Subject: RE: Planning Consultation on: Y/151/20/PL

Engineers Comments Regarding Surface Water Drainage

Site Address: Pollards Nursery Lake Lane Barnham PO22 0AD
Grid Reference: 496728 104599
Description of Works: Permanent siting of temporary seasonal horticultural worker' accommodation (8 mobile homes & 3 retrospective mobile homes), hardstanding & service building. This site also lies within the parish of Barnham, is in CIL Zone 3 (Zero Rated) as other development.

Appendix III – Drainage Plan

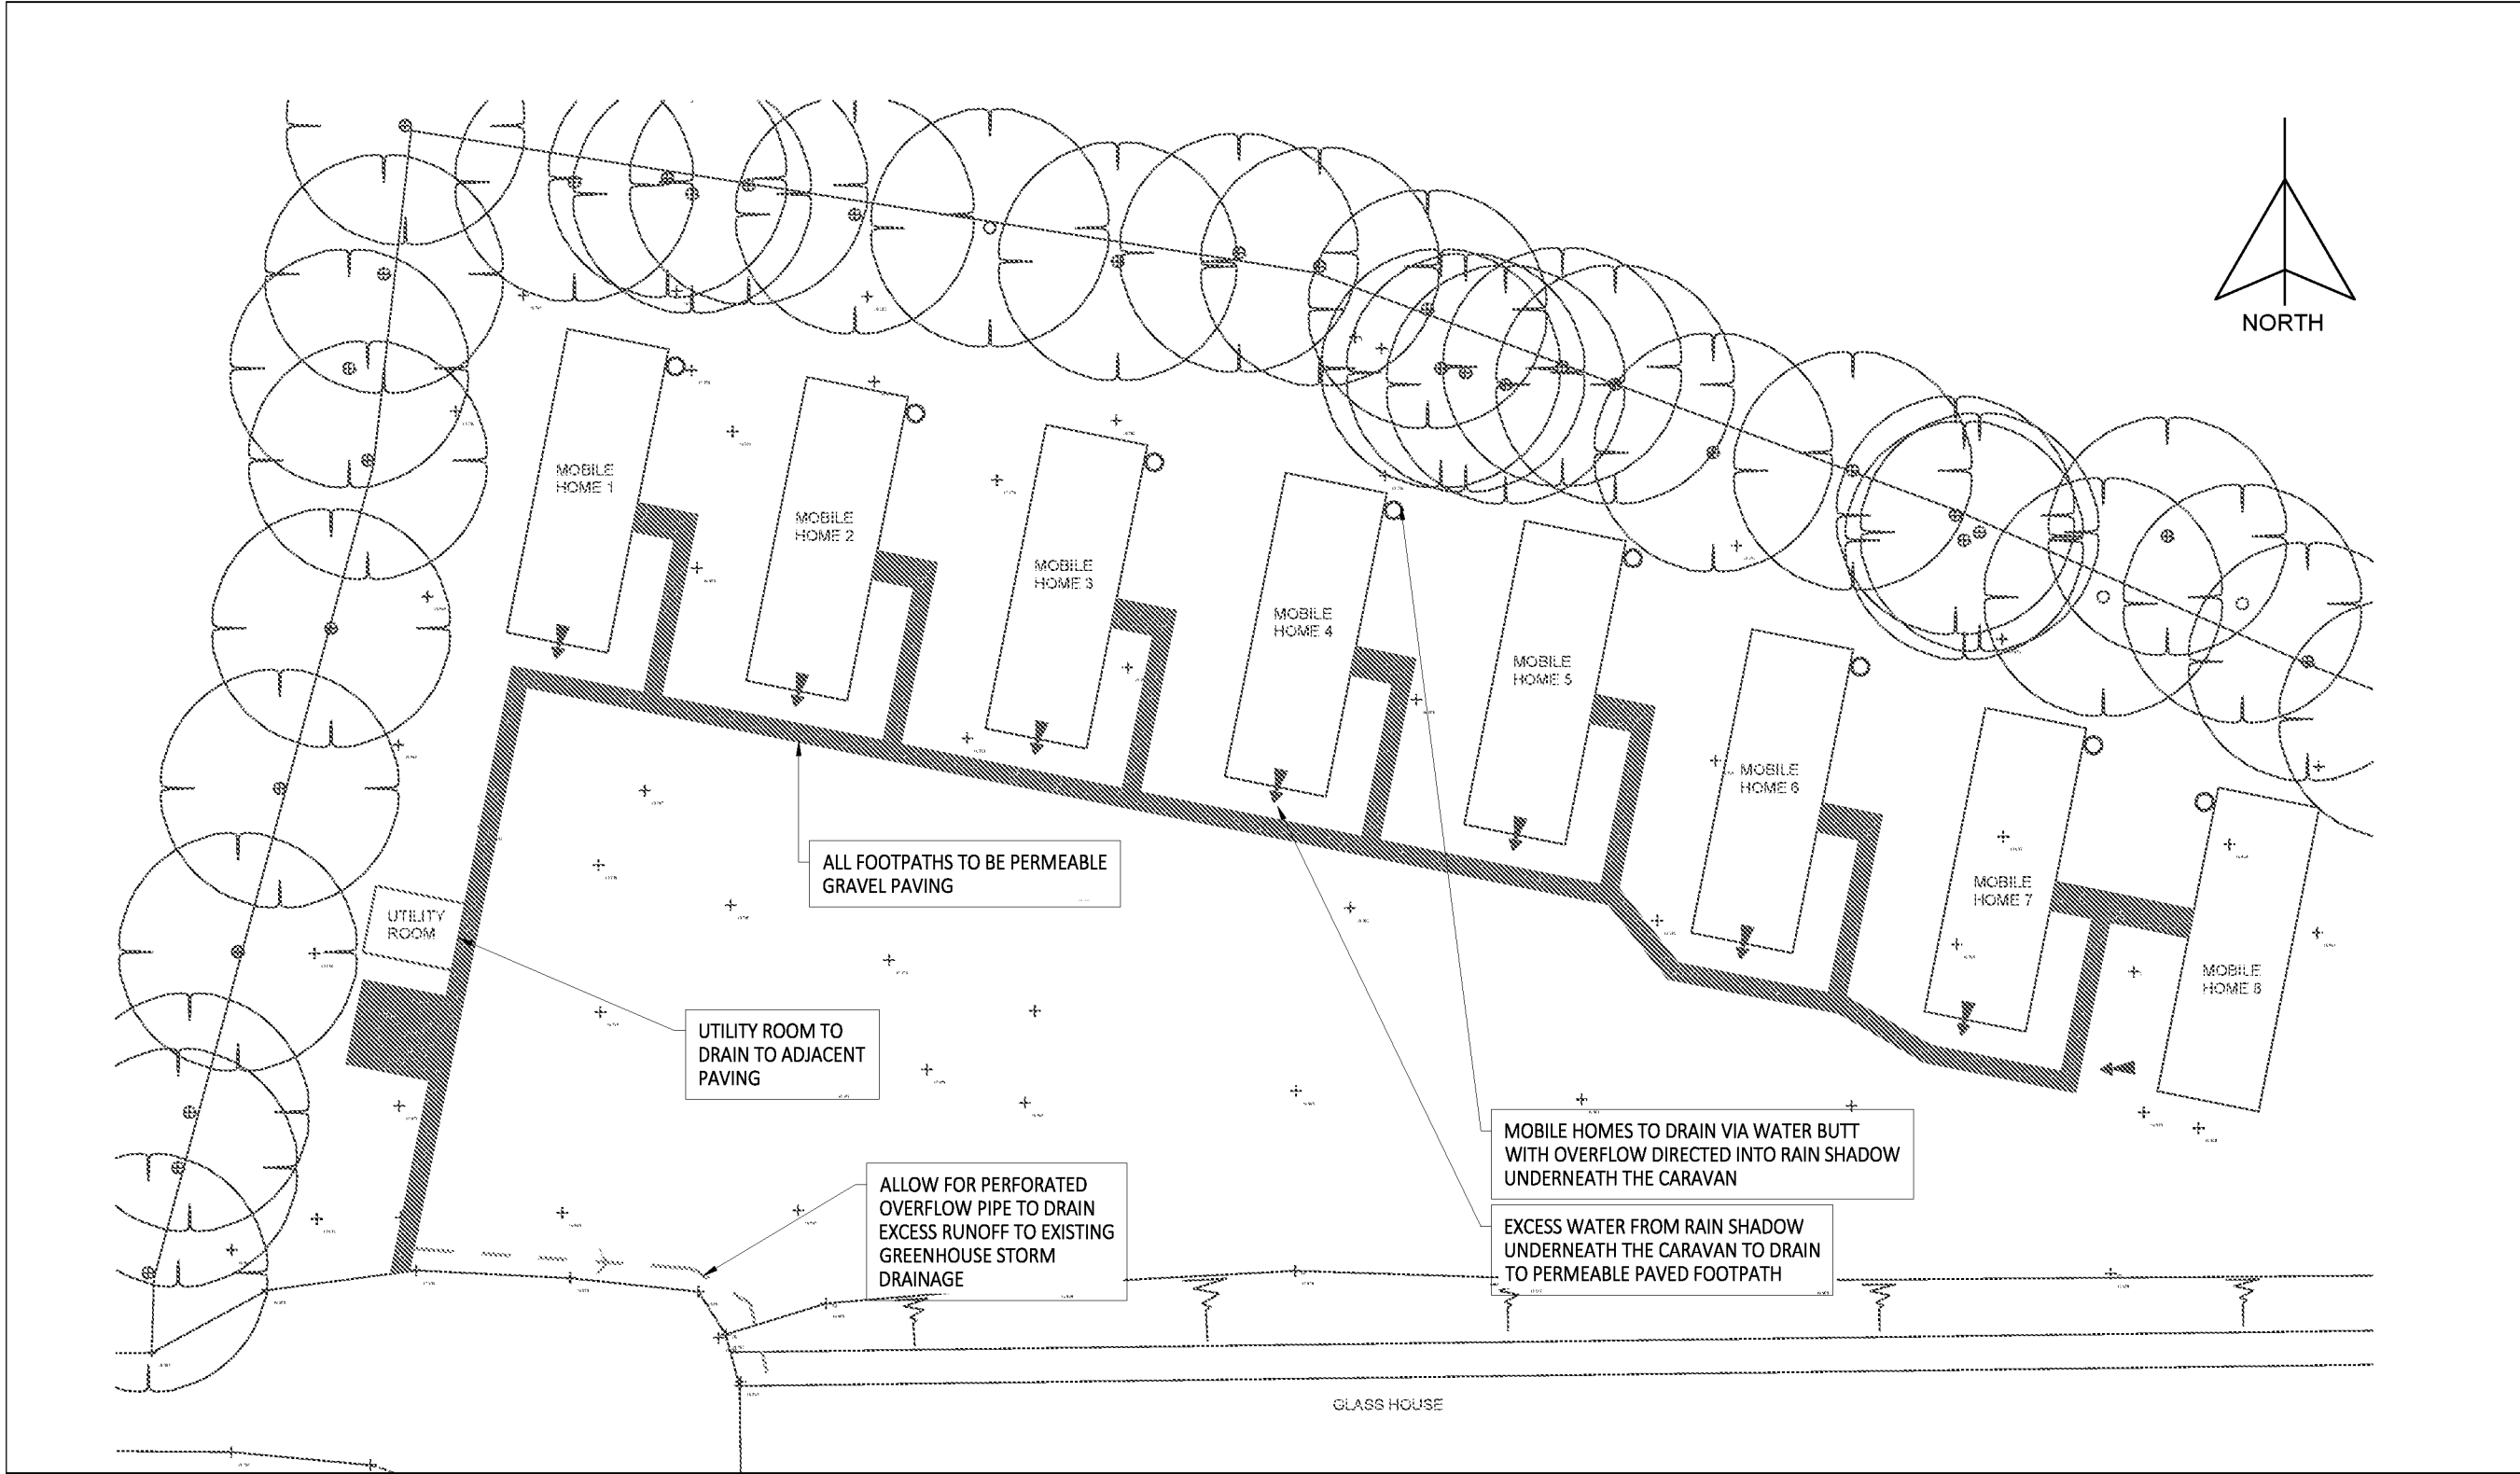
The applicant is proposing to capture surface water in water butts for reuse by residents, this is acceptable however the volume should not be included in the attenuation calculations. It is then proposed that the mobile units and access drain via permeable paving which will also provide water treatment and limited infiltration. I would like to see infiltration testing repeated at a depth that corresponds with the formation depth of the permeable paving so that it can be accurately determined whether or not attenuation is required.

The applicant proposes that the permeable paving will convey water to an attenuation system which can direct to the reservoir on site or the watercourse in adjacent Lake Lane. We would be keen to minimise any surface water leaving the site and would encourage any effort to reuse the water for the business. We would also need to understand the present onsite drainage arrangements/water recycling, if this option forms part of the solution.

As no final drainage strategy has been submitted please apply standard condition PCENG2 and PCENG3 if you are minded to approve this application, this will ensure flood risk is not increased elsewhere.

Trial Pit No:	TP1	Test No:	1	Date:	17/11/2020
Length (m):	1.300	Datum Height:	0.00 m agl		
Width (m):	0.30	Granular infill:	None		
Depth (m):	1.50	Porosity of infill:	1	(assumed)

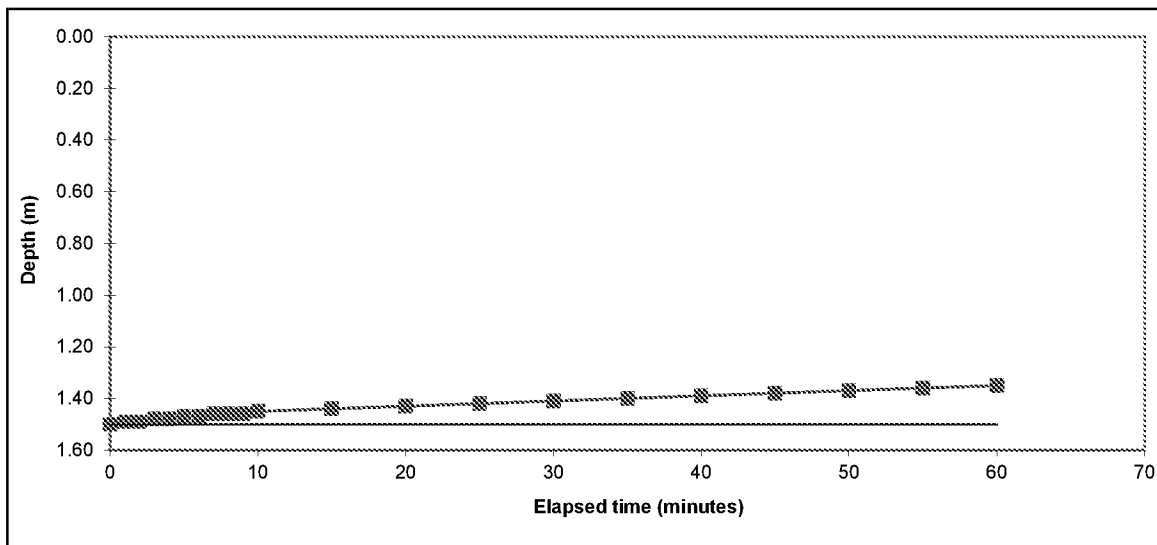
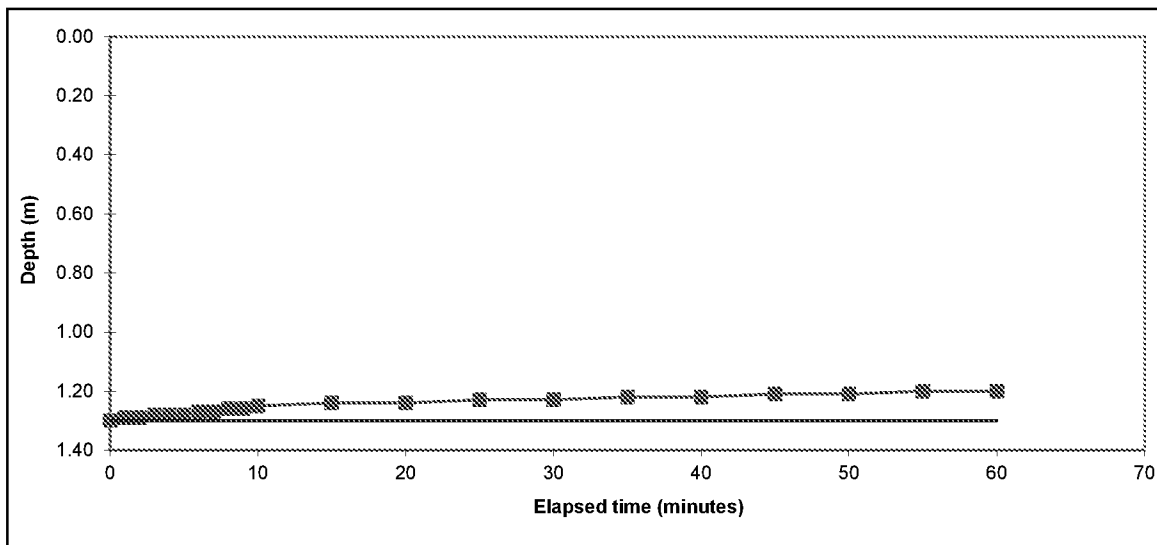
The applicant has submitted a SuDS and Surface Water Drainage Assessment as part of this application. They have undertaken two infiltration tests in November 2020 which have shown infiltration not to be viable at 1.5mbgl and 1.3mbgl. Groundwater is noted to rise to between 1.35mbgl and 1.2mbgl. The results are not surprising as testing was carried out too deep and shallow infiltration potential needs to be investigated. We expect infiltration testing to be completed in the winter when ground conditions are at their worst ie. January/February/possibly early March, and above peak winter groundwater levels (trial hole to be carried out at an agreed time ie. immediately, to determine potential groundwater levels). In addition, the infiltration test depths will need to correspond with the formation depths for the permeable paving (which the applicant is proposing).
